From: Robin Uff [REDACTED]
Sent: 16 June 2010 13:15
To: Jackie Phillips
Cc: Robin Uff
Subject: 10 Park Street, Old Hatfield, HATFIELD- S6/2010/0534/LB

Grade II listed building; conservation area.

Appendix 5a: Existing rear elevation of the area work is proposed to a scale of 1:20
10 Park Street, Old Hatfield, Hertfordshire, AL9 5AX.

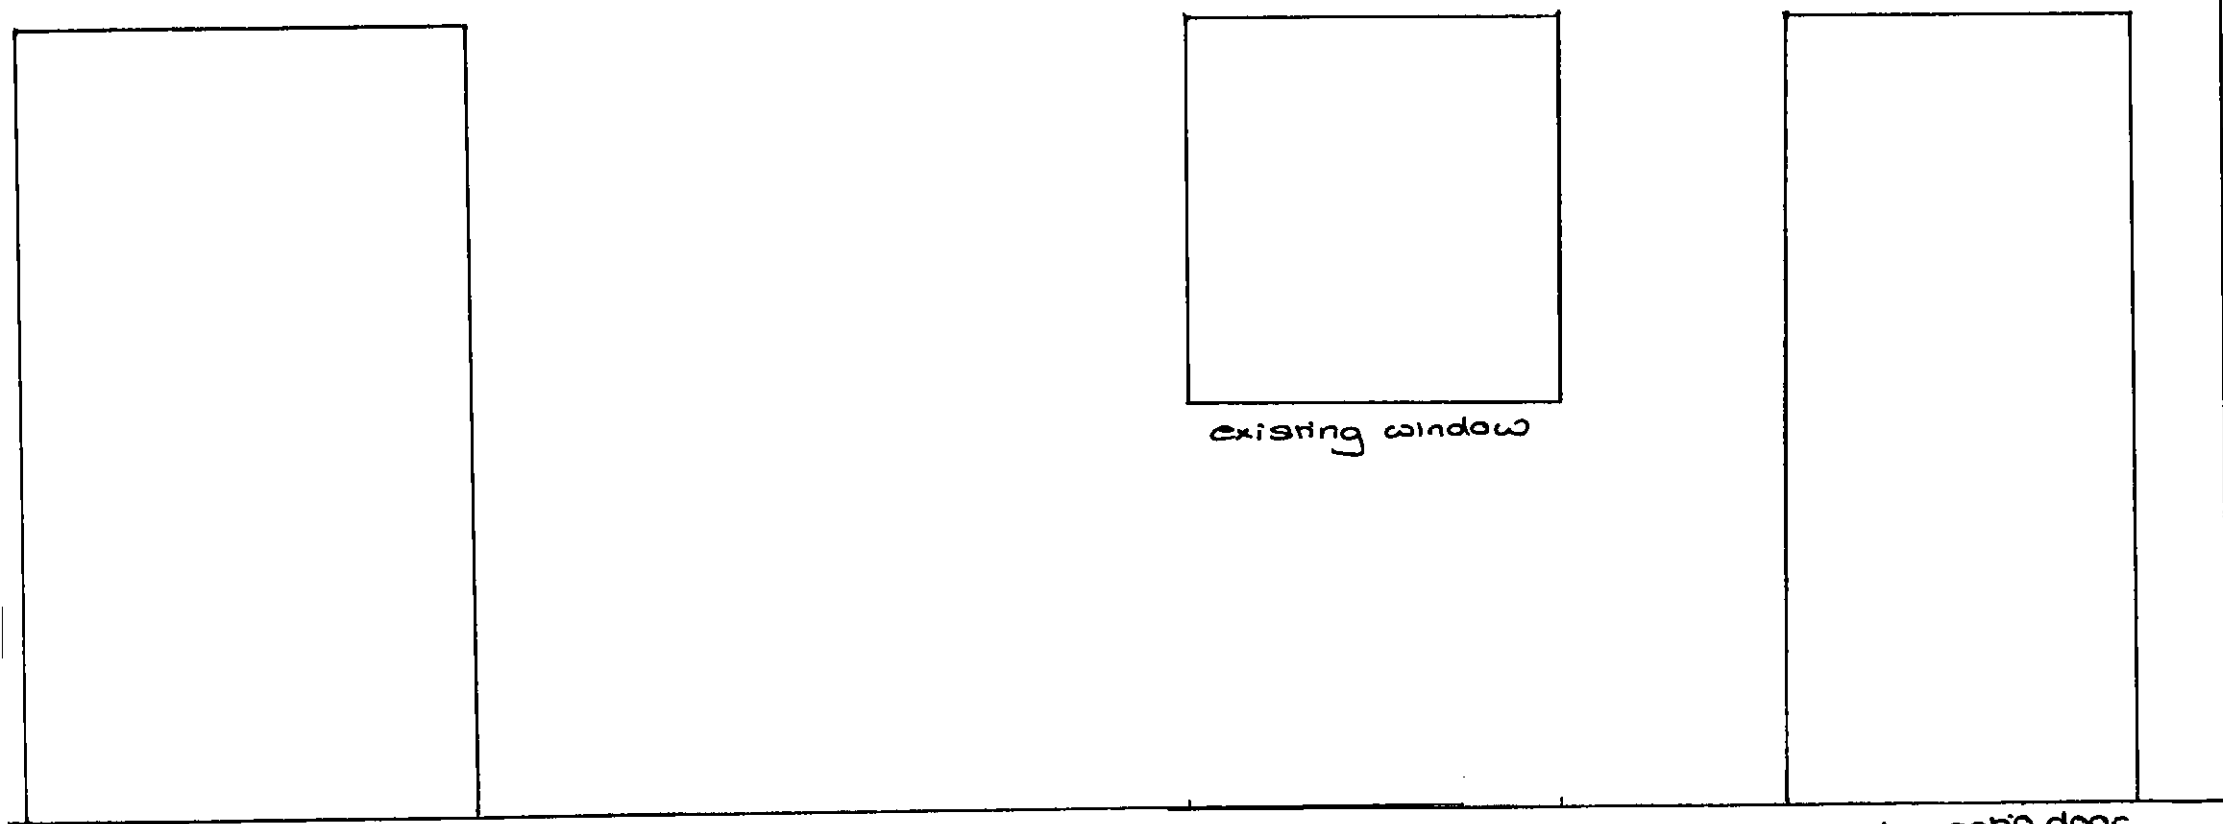
I eventually visited the house on Friday 11 June- sorry for the delay. As noted in earlier advice (4 June), the drawings & supporting documents are rather lacking in detailed information. The structure of the rear wall is not provided. The front (street elevation) wall is still the red stock brickwork of the encasing referred to in the list description- but the side & rear wall are now covered in a unsuitable modern-looking, presumably cement-based, render.

Whilst the proposed alterations- **replacing the rear door with a window & increasing the existing ground floor rear window opening size by lowering the sill** are likely to be acceptable in principle, so long as the back wall is brickwork, the unknown element is whether any of the possible earlier timber frame is still forming that rear wall. If so, then this alteration to the wall will need to be designed in further detail, so as to avoid any possible damage to the historic frame. For exmple, there could be a brace or interesting carpentry jointing in this area of wall framing the existing window.

I suggest requiring the applicant/ agent to investigate the structure/ fabric of that rear wall, in order to establish the facts & to enable a final decision to be reached. Or- alternatively- refuse for lack of sufficient detailed information.
